16th December 2022

CROW TREES FARM, CHATBURN BB7 4BA APPLICATION FOR 39 RESIDENTIAL UNITS ETC. 3/22/0966 : LETTER OF OBJECTION

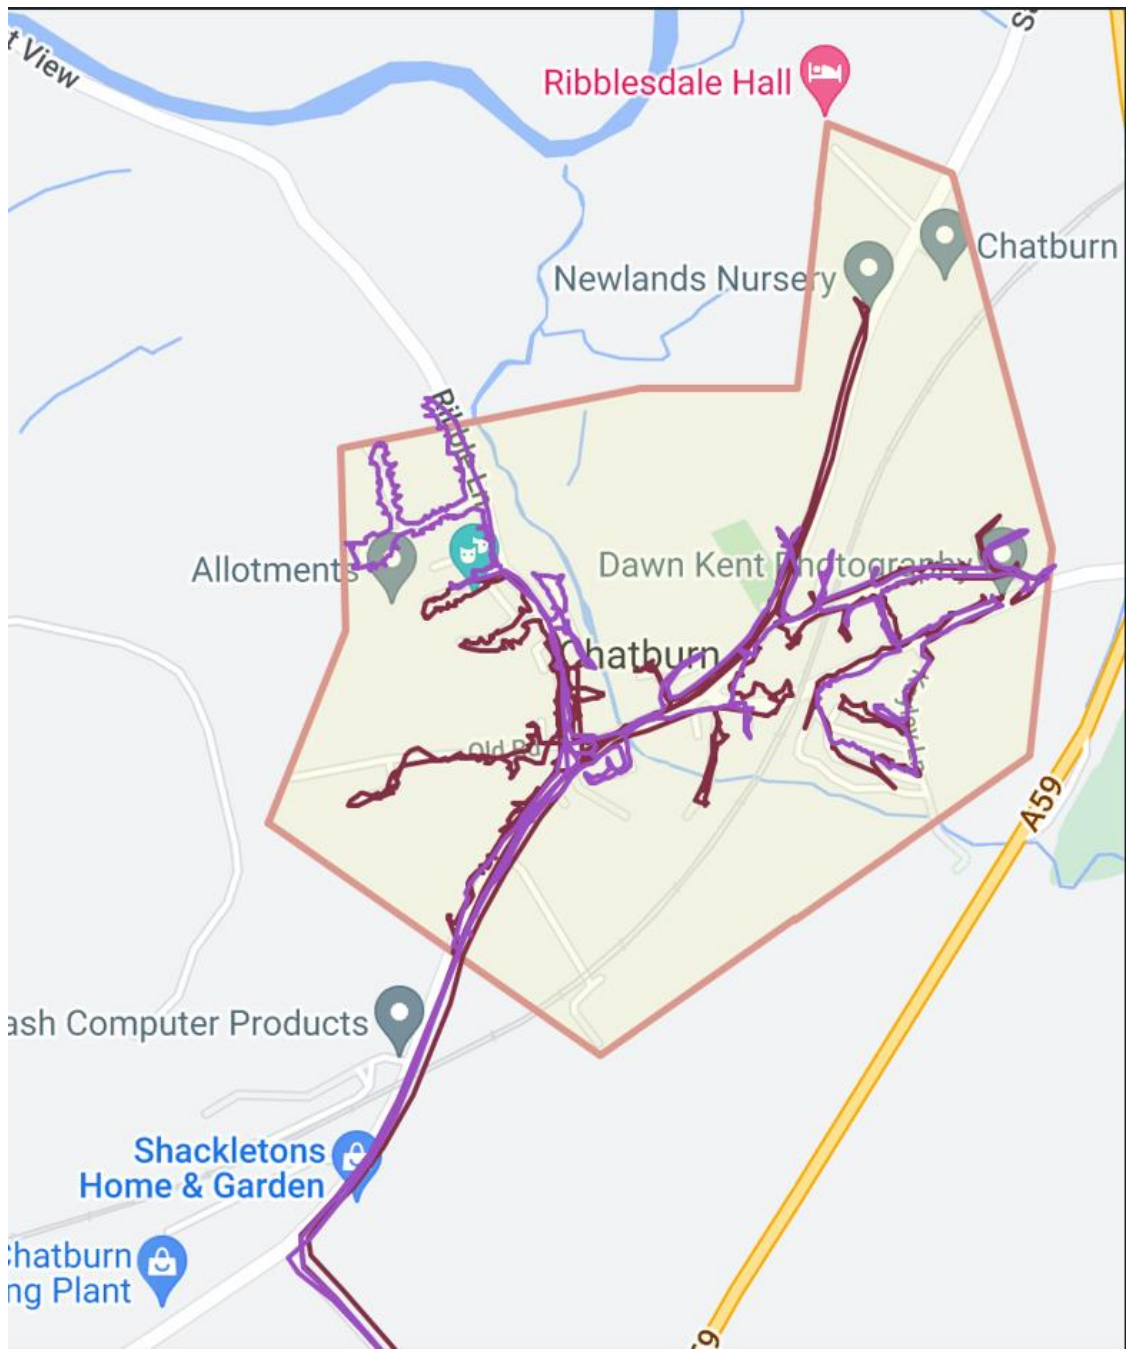
The application site is within the Chatburn Conservation Area. The new build housing is principally outside of the Conservation Area except for the back gardens to plots 1-4.

With the above in mind, the only concession the new build housing scheme makes to the presence of the listed building is to step the housing down to one storey close to the listed farmhouse. The suggestion made in the Planning Statement that this *"would enable views from the farmhouse to be largely maintained looking outwards 'over' the land"* is not agreed **because the view would simply be of further houses to the south.**

The 39 new dwellings is a high density (39 dwellings/1.3ha =30 dwellings per hectare) standard housing scheme which does not preserve or enhance the conservation area as required by Section 72 of the Planning (Listed Building and Conservation Areas) Act 1990. In addition, the proposed new build housing would have an adverse impact on the setting of the listed building, contrary to Section 66 of the Act. **As a result planning permission should be refused.**
